Rezoning Transportation Analysis

Petition Number: 2020-068

General Location Identifier: Tax ID. 17514688

Date	Description
05-18-2020	First Review
06-28-20	Second Review

SCHEMATIC SITE PLAN
PETITION # 2020-068
FOR
HEDGEMORE - MONTFORD PARK
CHARLOTTE, NORTH CAROLINA 28209

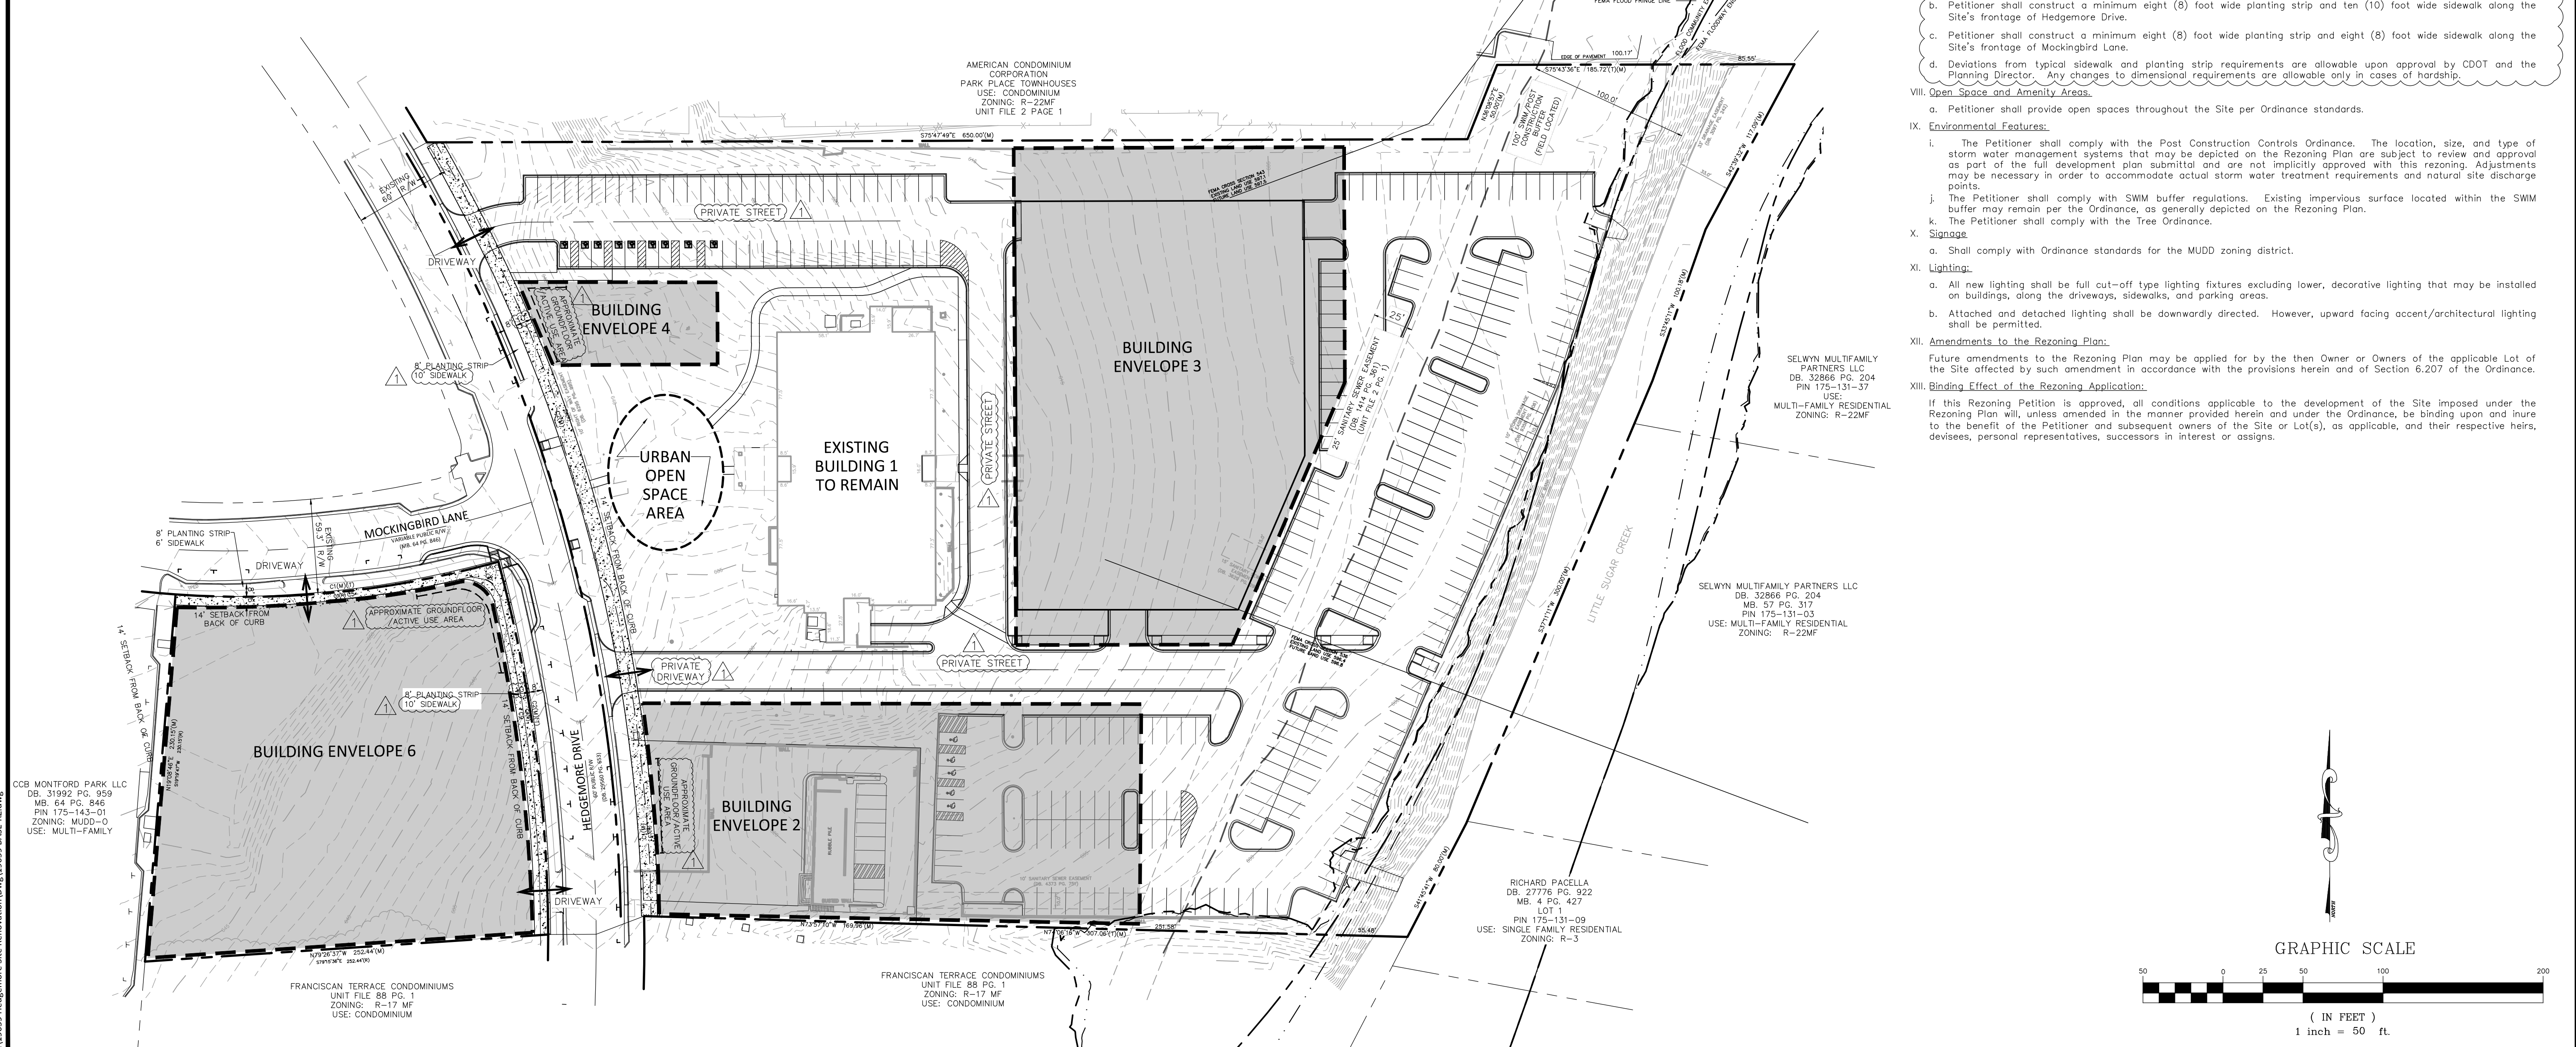
- Curblines** The proposed zoning district has a setback measured from back of the existing or proposed future curblines.
 - Hedgemore Drive:** The future location of curb and gutter is in its existing location.
 - Mockingbird Lane:** The future location of curb and gutter is in its existing location.

The site plan should show the curb and gutter labeled and dimensioned from the centerline for each road.

- CDOT requests that the petitioner revise the site plan and conditional note(s) to commit to a 12' multi-use path connecting Hedgemore Drive to the Cross Charlotte Trail (XCLT) including a pedestrian bridge over Little Sugar Creek east of the site, to meet the City of Charlotte BIKE Policy. CDOT also requests a public access easement with parking and a trailhead to the XCLT as a Traffic Demand Management (TDM) measure.

- The petitioner should revise the site plan and conditional note(s) to commit to constructing an 8-foot planting strip, and an 8-foot sidewalk on Mockingbird Lane per the Park Woodlawn Area Plan. The site plan should label and dimension both items from the back of curb and gutter to the road centerline.

- The petitioner should revise the site plan to add a note specifying dedication and fee simple conveyance of all rights of way to the City before the site's first building certificate of occupancy is issued. CDOT requests right of way set at 2' behind back of sidewalk where feasible.
- The petitioner should revise the site plan to add a note specifying all transportation improvements will be approved and constructed before the site's first building certificate of occupancy is issued. The petitioner may phase transportation improvements if said improvements and phasing are explicitly described in site plan notes.
- Resolved** - Sample format for comment that is resolved
